# Planning Services Sign Permit Review Form

Date of Submittal	Application Number	Applicant	Landowner
<b>6/17/2022</b>	<b>SIGN2206-0002</b>	<b>Post Nursery</b>	<b>DRB Group</b>

Contact Person	Post Nursery	Contact Number	(919) 554-4002
Sign Location	NC 210 N & Hayfield Drive	PIN Number	0662-10-5154.000

Site Plan

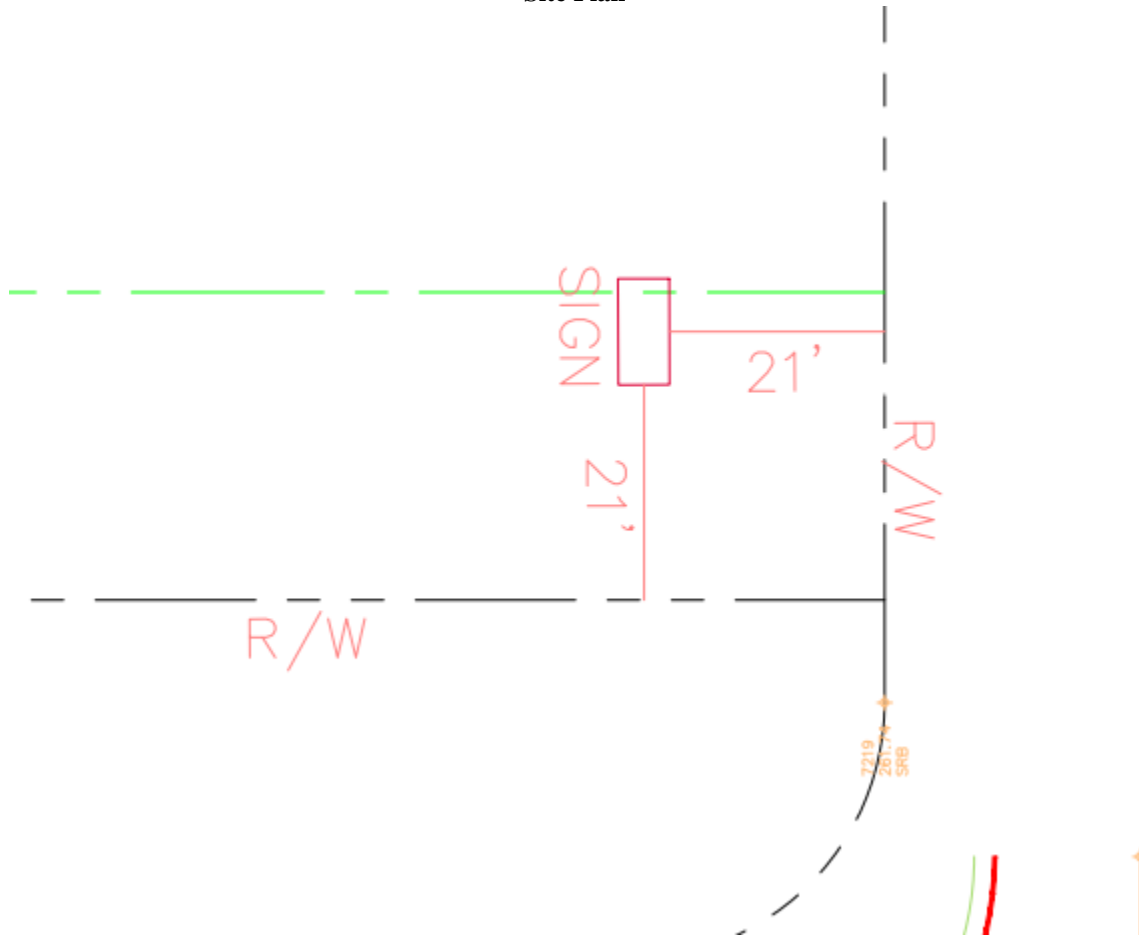
Comments	Need verification of location of sign measurements from property lines that abut NC 210N and Hayfield Drive. Overall measurement of sign must not exceed 50 square feet.
----------	--
